**KIRKLEES COUNCIL
TOWN AND COUNTRY PLANNING ACT 1990
HIGHWAYS DEVELOPMENT MANAGEMENT**

PLANNING REF 2017/62/91748/E0/LB
CATEGORY Minor

PROPOSAL DEMOLITION OF 1 DWELLING AND
ERECTION OF 4 DWELLINGS

LOCATION 113 WESTFIELD LANE
WYKE
BD12 9LY

Site layout 1:200

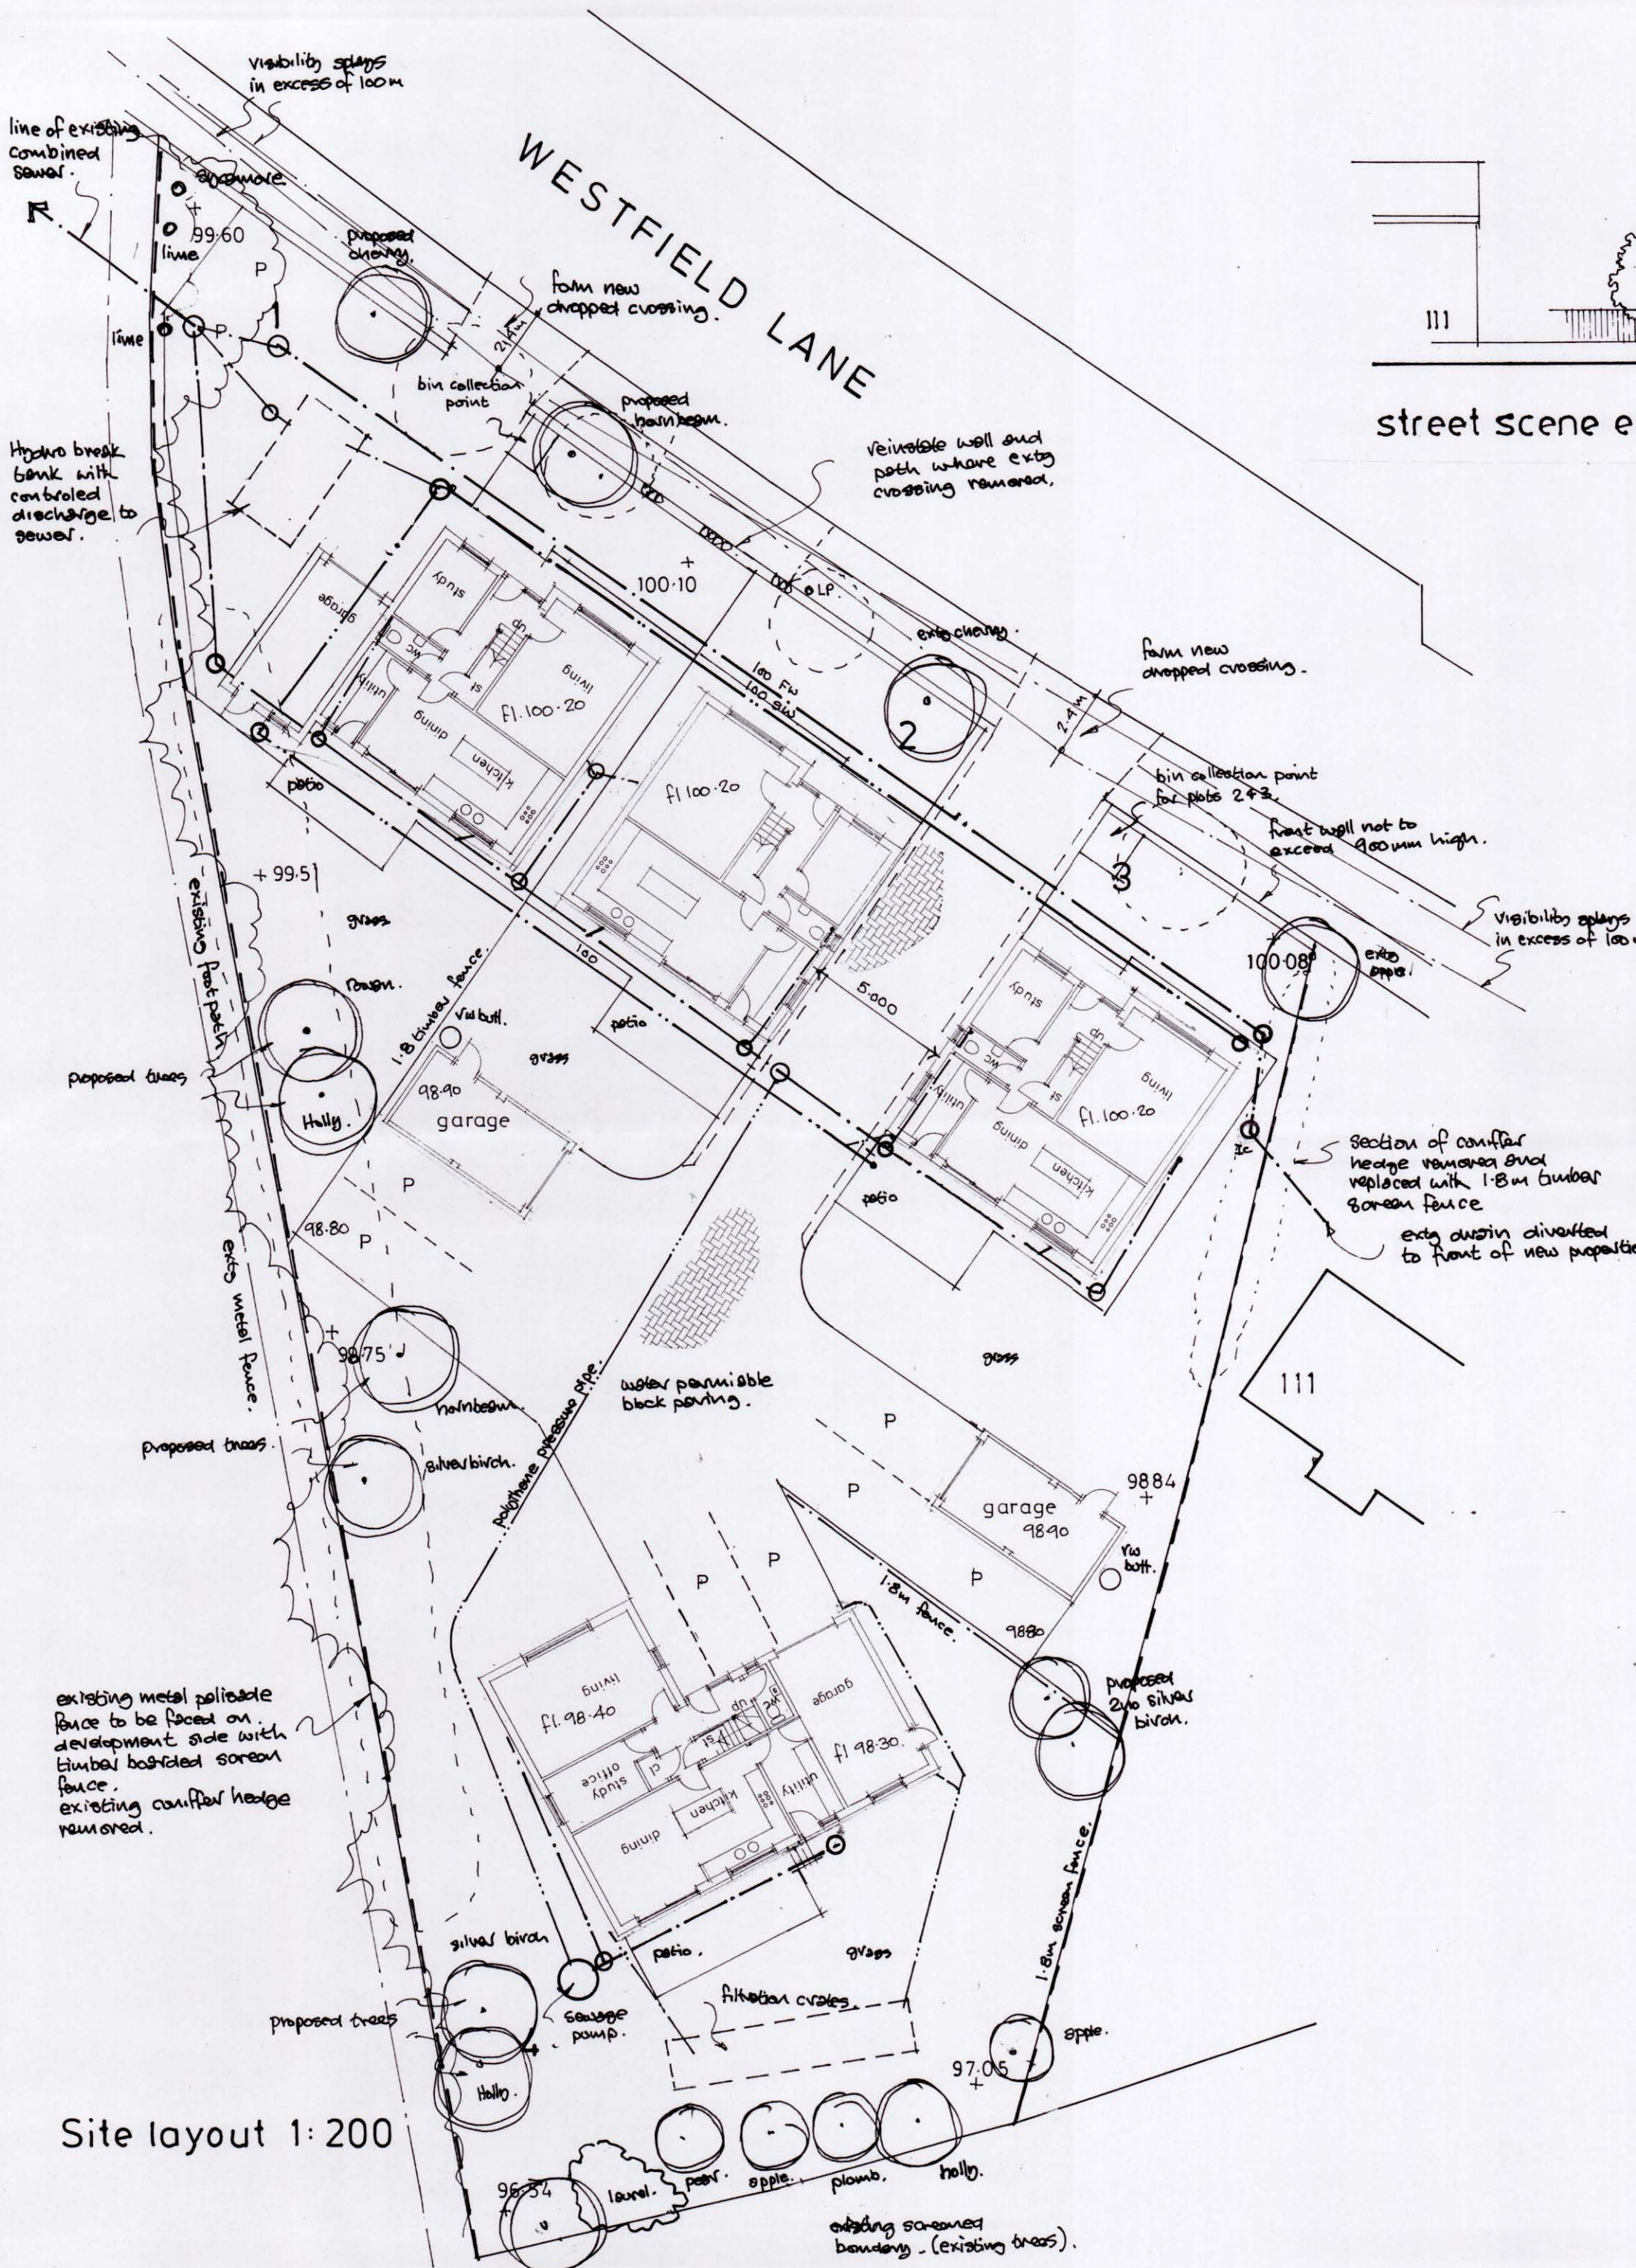
Two points of vehicular access are proposed with a secondary access providing direct access to one individual property.

The levels of vehicular visibility splays at each access are considered acceptable.

The accesses are considered acceptable in terms of their geometric design. The access to the private access-way is 5.0m in width which is wide enough for two cars to pass and wide enough for a car to pass a larger service vehicle. This is in line with the guidance contained within "manual for Streets".

Sufficient manoeuvring space exists within the site, and refuse collection details are considered acceptable.

1) Before development commences, the vehicular visibility splays as shown on drawing no: "Site Plan 1" shall be cleared of all obstructions to visibility exceeding 1 m in height and these shall be retained free of any such obstruction.
